Byers Gill Solar
Local Impact Report - Landscape and Visual Amenity
Darlington Borough Council

July 2024

Glenkemp Landscape Architects

1.1 Glenkemp Landscape Architects has been appointed by Darlington Borough Council (DBC) to prepare this Local Impact Report on landscape and visual amenity matters in relation to the Byers Gill Solar development. Glenkemp was initially appointed in July 2023 following publication of the Preliminary Environmental Information Report (PEIR) in May 2023. Glenkemp undertook a review of the proposals and methodology set out in the PEIR and advised Darlington Borough Council through subsequent (topic specific) consultations with the Developer. This document sets out the Council's response to the proposals and predicted landscape/visual amenity effects described in the Developer's Environmental Statement (ES). It forms part of the overarching Local Impact Report prepared by DBC as required under the application process for a Nationally Significant Infrastructure Project (NSIP). Primarily it deals with potential impacts which occur within the Darlington administrative boundary but also describes impacts affecting adjacent local authorities where relevant

Drawing Title
**Figure 7.6.1
 Key Settlements: Brafferton**

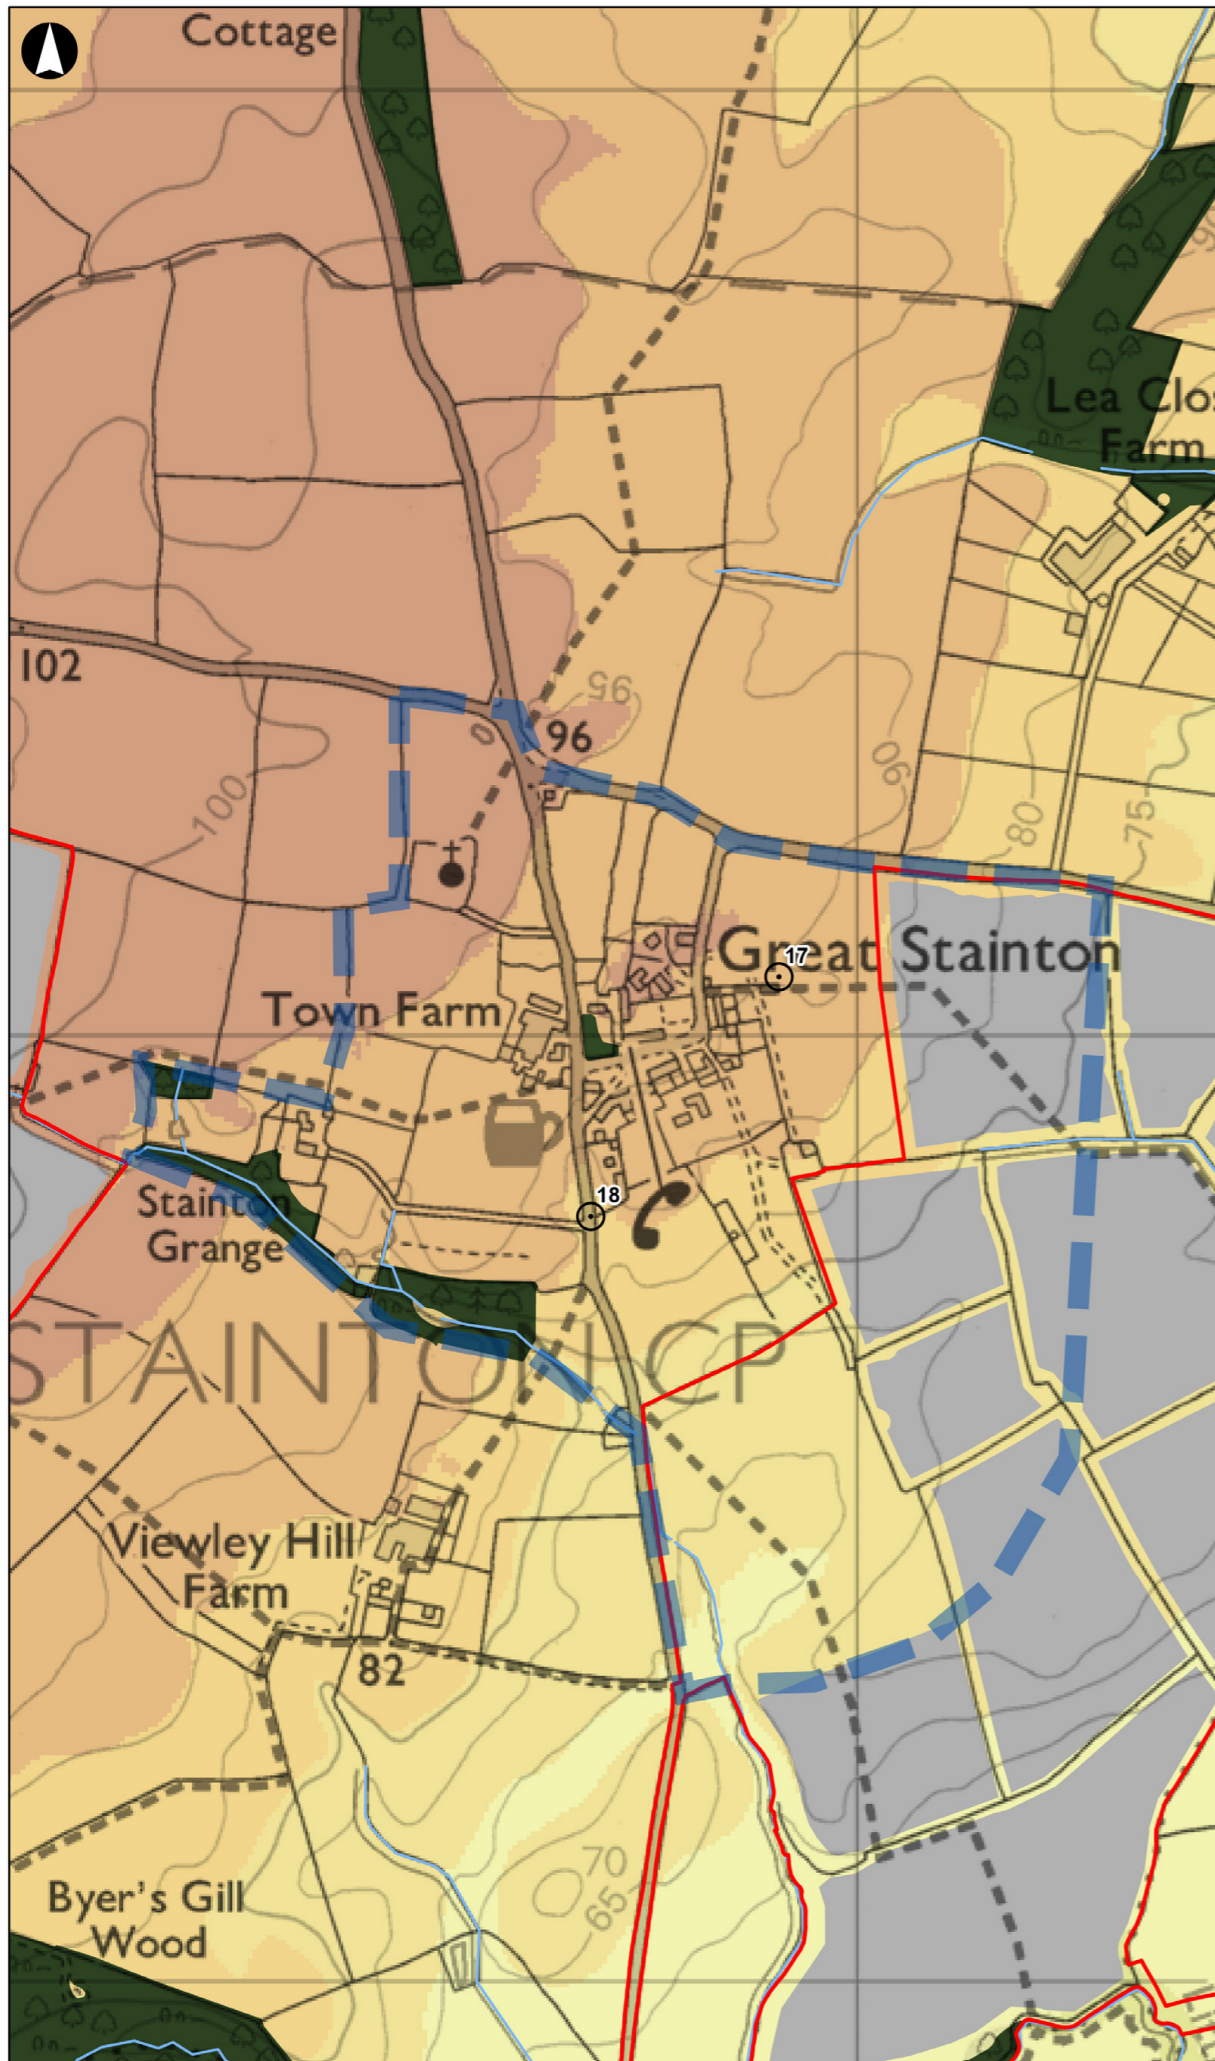
4.8 ES Chapter 7 provides a reasonable description of the baseline for each of the three villages. Figure 7.6 in the ES provides plans showing the extent of the setting for the villages assessed by the Developer. This information was requested by DBC after the Council had concerns about the potential significant effect on the setting of the villages. DBC is of the view that the area of land identified as the village setting in Figure 7.6 has been understated and therefore the magnitude of change on the villages is also likely to be understated. This is considered in further detail below and also in Section 8 of this Report.
